Department of Primary Industries

Grafton Correctional Centre (SSD 7413) Comment on the Environmental Impact Statement

19 September 2016

Figure 4-5 | Elevation and drainage features

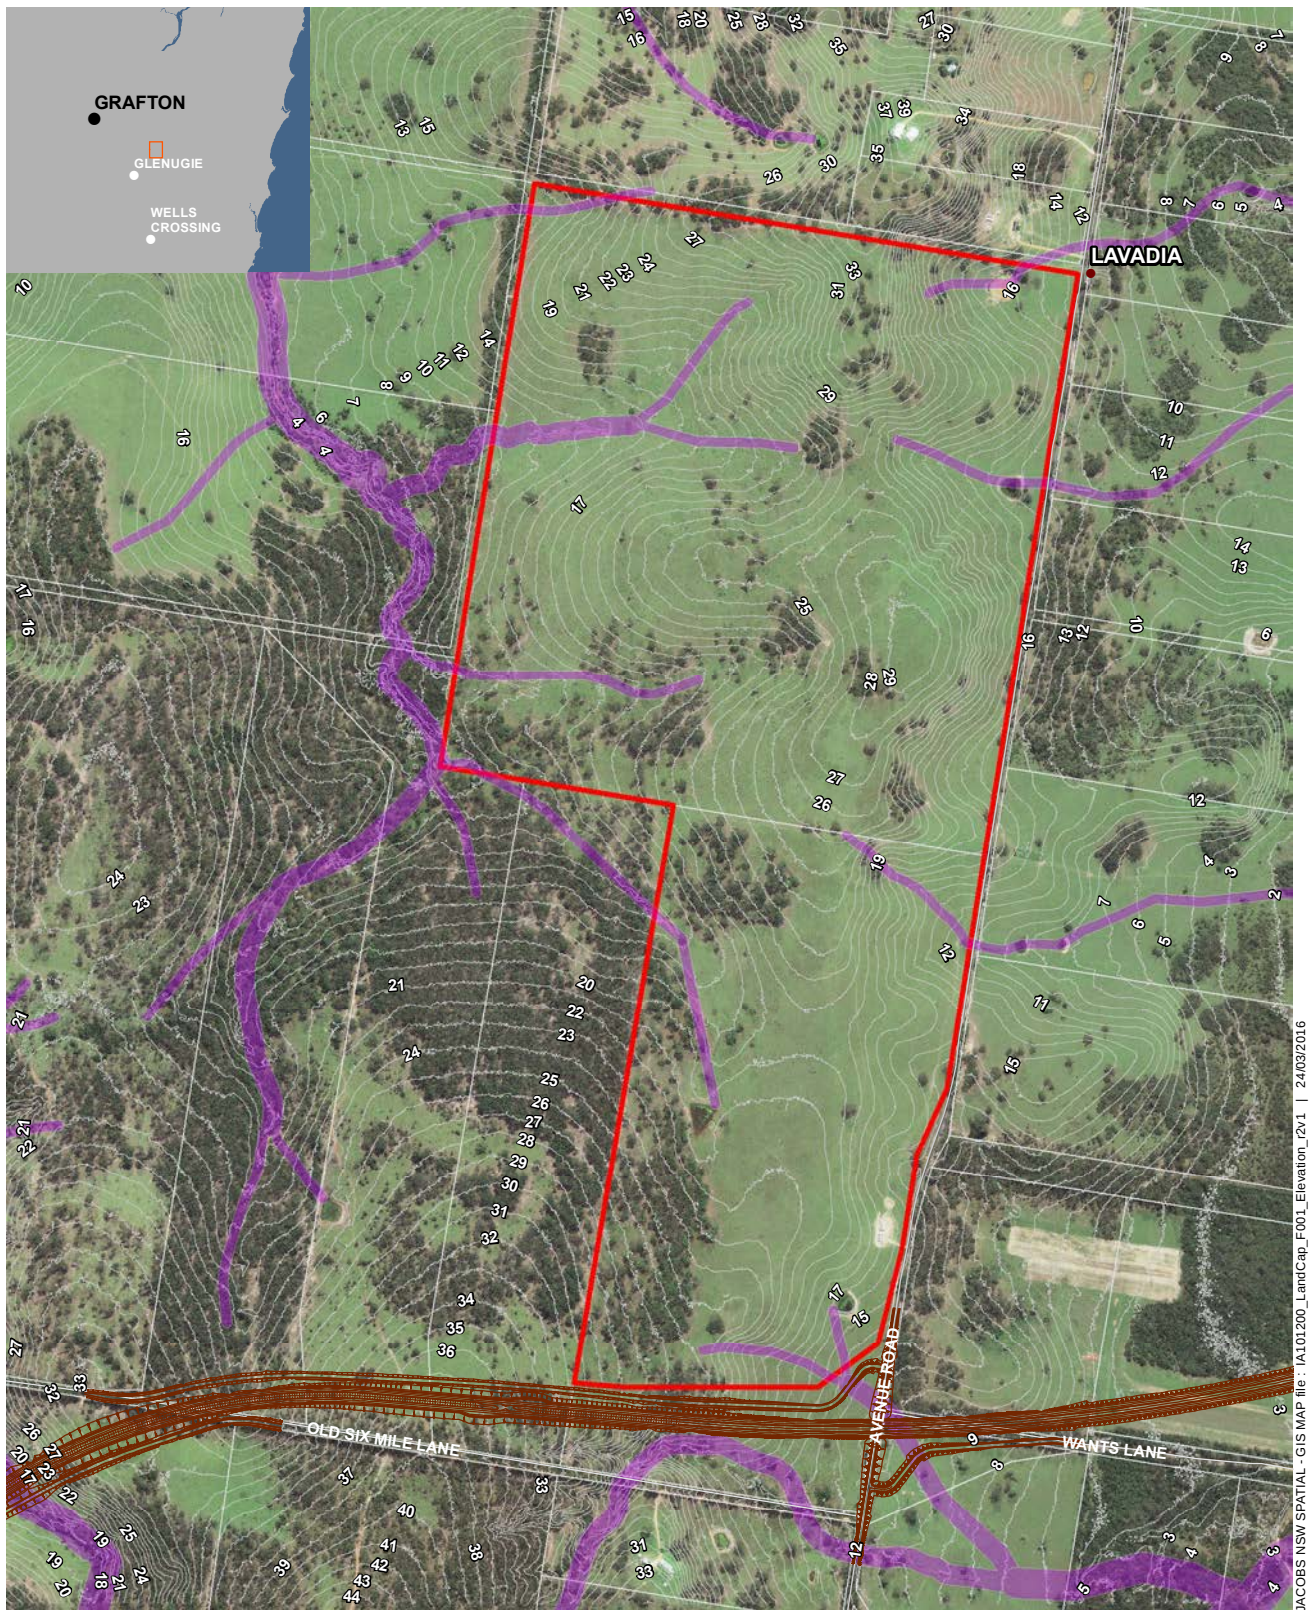
- The proponent should provide details on the proposed management of drainage lines traversing the project site. All works associated with these drainage lines should be undertaken in accordance with [DPI Water Guidelines for Controlled Activities](#).
- The EIS outlines a number of possible options for the supply of water to the site. Once a final option for water supply is determined the proponent should consult with DPI Water on implementation and operational requirements.
- The proponent should provide detail on any potential impacts on groundwater, including mitigation measures such as lining sediment basins or monitoring groundwater.
- The proponent should consider appropriate buffers between groundwater bores and septic systems as outlined in the relevant Water Sharing Plan when developing plans for the treatment and reuse of operational wastewater onsite.
